DECISION DELEGATED TO DEVELOPMENT MANAGER

Application No:	H13-0976-20	Applicant:	Mr N Giles
Proposal:	Erection of dwelling		
Location:	Adj. 48 Seas End Road Moulton Seas End Spalding		
Terminal Date:	28th December 2020

CASE OFFICER ASSESSMENT

Proposed Block Plan (1:250)

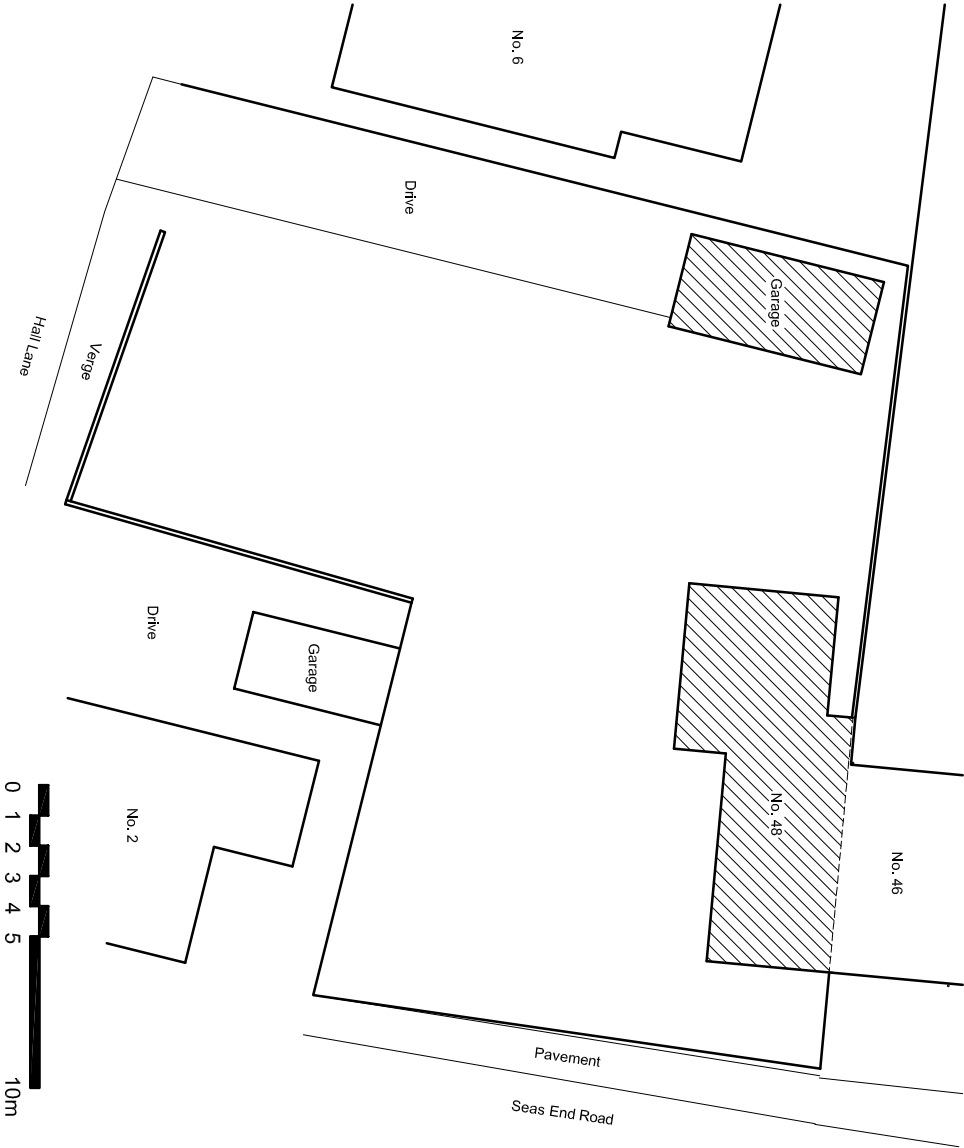
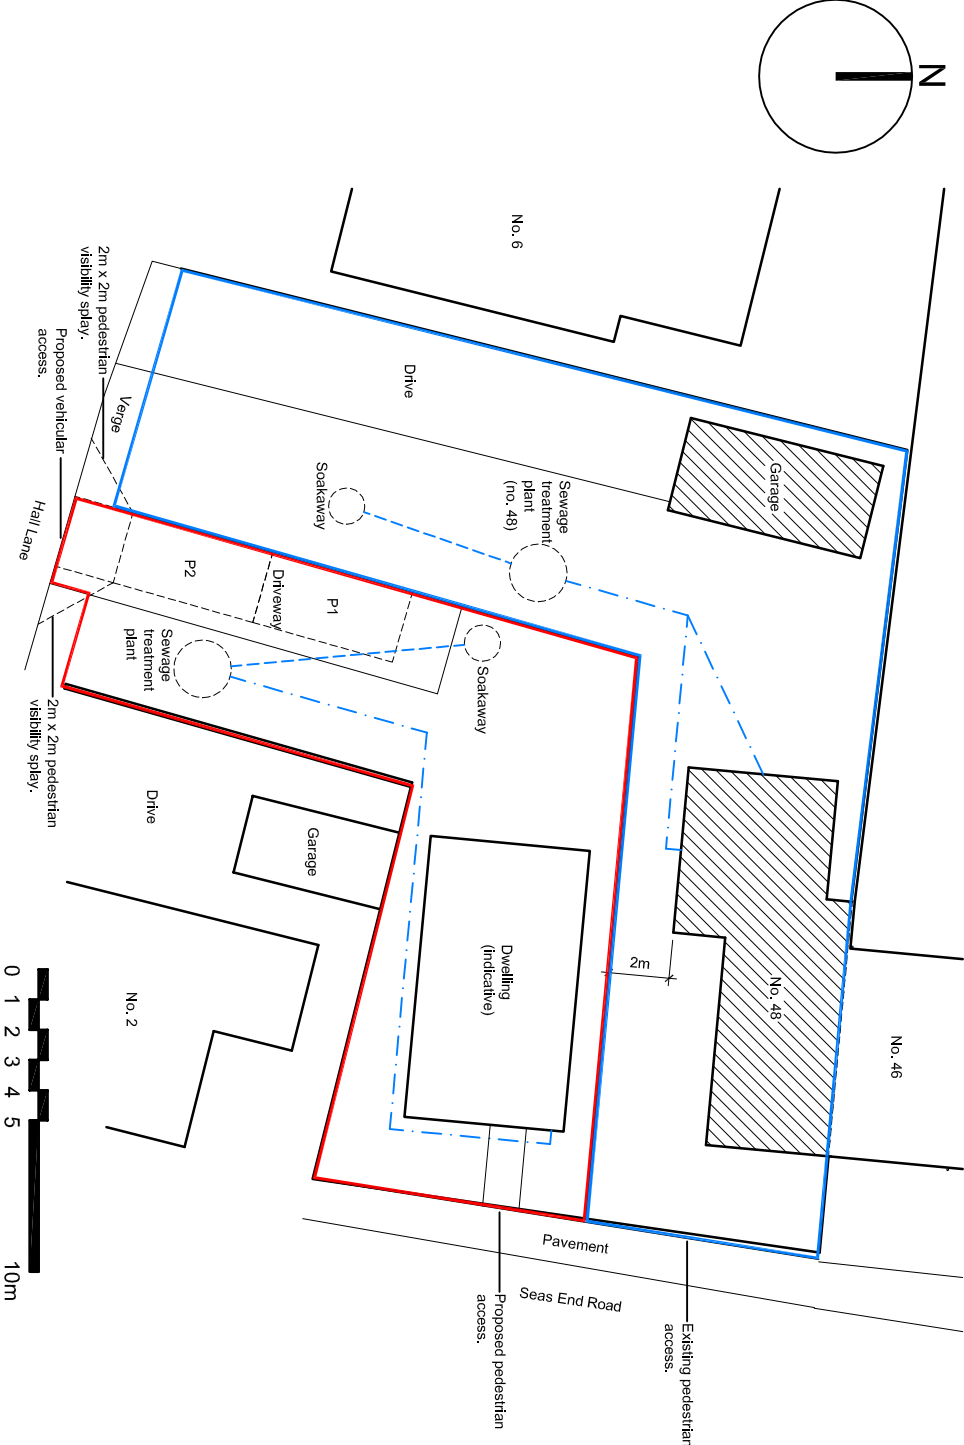
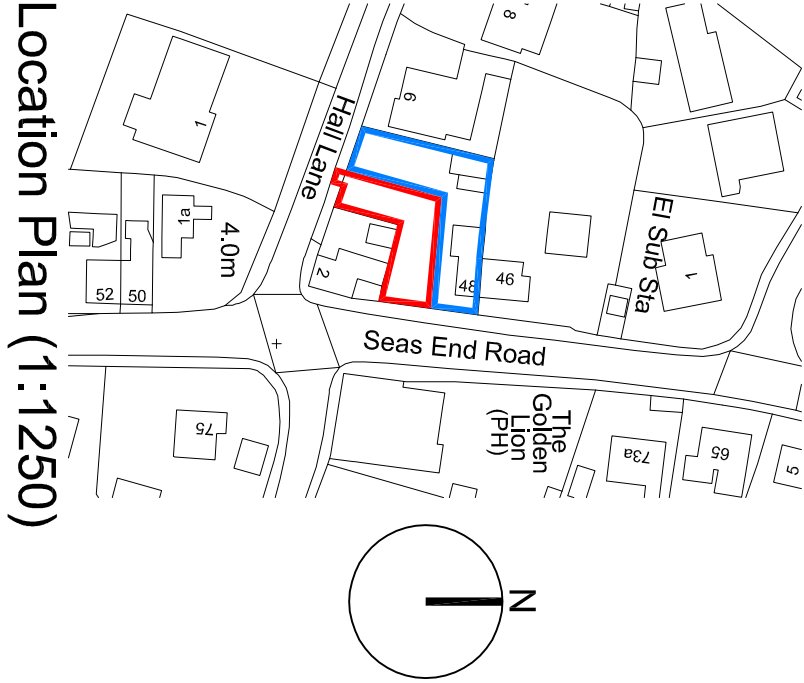
The indicative block and floor plans show a two-storey dwelling (approx. 5.3m in width, 9.3m in depth) fronting on to Seas End Road, with parking located to the rear off Hall Lane. The frontage on to Seas End Road measures approx. 8.5m which, although is modest, is adequate for a small dwelling to sit within and a reasonable separation distance be maintained to existing dwellings either side. Furthermore, the former garden area to the side and rear of the property adjoining no. 48 already benefits from outline planning permission for 2 dwellings, thus the principle of developing along this frontage has been established.

Both no. 48 Seas End Road and no. 2 Hall Lane have non-obscured window openings at first floor and face the site. However, a property could be designed that has no side facing windows to habitable rooms, or could be obscure glazed if secondary windows. The site wraps around the side of no. 2 Hall Lane, where two parking spaces and a sewage treatment plant are indicated on the indicative block plan, and is an area which is overlooking by what is presumed to be a bedroom window. Although the site is currently garden belonging to no. 48 Seas End Road and occupants could feasibly regularly use that part of the land as it stands, it would be preferable if that part of the site were not to be designed as part of the garden space so as not to attract occupants to spend any period of time in that location. A condition can be added to the decision notice to that effect if permission were to be granted. It is accepted that this would restrict the usable external amenity space associated with the property, however surrounding development in the immediately vicinity is typically characterised by small gardens. In terms of the likely relationship with no. 48 Seas End Road, the garden area would most likely be at an angle from its first floor windows, thus minimising overlooking, and the relationship would arguably be no different to the rear windows of frontage development overlooking neighbouring gardens. The windows also appear somewhat reflective.

It is noted that a dwelling designed to front onto Seas End Road would be sited due south of no. 48. In view of the sun path, the potential for overshadowing and loss of light to habitable spaces of that dwelling is an issue to consider. Habitable rooms/spaces that are of concern are the master bedroom (to which there are two windows at first floor) and the kitchen and dining areas (to which there is a window and French doors at ground floor). It is not expected that the actual separation distances between the side elevation of a proposed dwelling that may come forward at reserved matters stage would be significantly different to the approx. 3m and 4.7m shown on the indicative block plan. The proposal has therefore been assessed on that basis. Given this proximity it is considered that, based on the 25 degree BRE sunlight/daylight test, a two storey dwelling in this location would have a detrimental impact on light levels to the kitchen and dining area at ground floor. It is considered that a single storey dwelling would be more appropriate. Therefore, if permission were to be forthcoming, a condition would be added restricting it to a single storey development. This would also avoid overlooking to the rear given that there is an approx. 17m separation distance between the indicative dwelling and side bedroom window of no. 6 Hall Lane

Given that it appears the intention is for the proposed dwelling to be sited to the north of no. 2 Hall Lane, it is not considered that there would be a detrimental impact on the occupants of that property in terms of overshadowing or material loss of light. A single storey dwelling would minimise the visual impact when viewed from the side facing windows.

Taking the above into account, and the opportunity to restrict the development to single storey, it is not considered that there is a material reason to withhold planning permission on amenity grounds. The proposal is considered to comply with Policies 2 and 3 of the Local Plan in this respect.

In light of the above considerations, the proposal is considered to be in accordance with Policies 1, 2, 3 and 4 of the South East Lincolnshire Local Plan (2019), as well as Sections 5, 12 and 14 of the National Planning Policy Framework (2019), subject to a condition restricting the development to single storey.

Indicative House Plans (1:100)

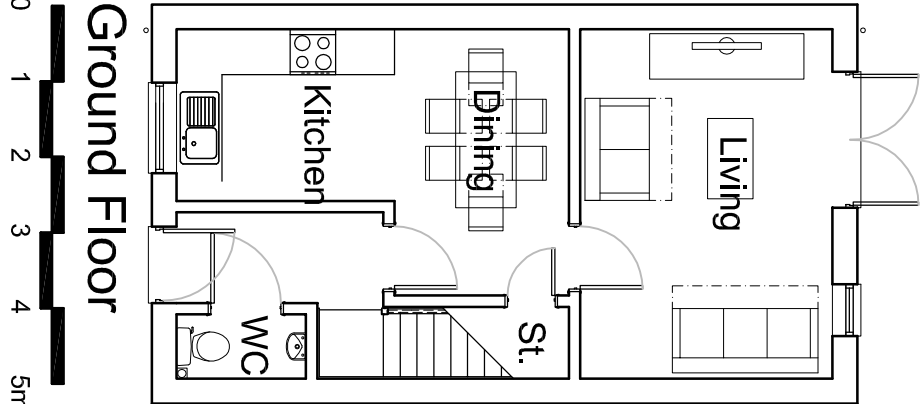
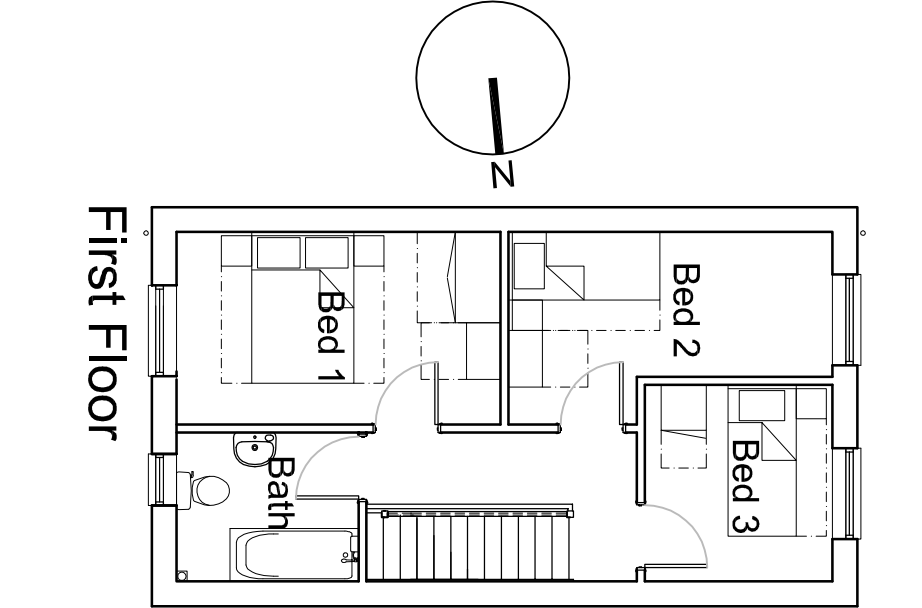
Parking provision can only reasonably be assessed at reserved matters stage as the submitted floor plans are merely indicative given the proposal is in outline form.
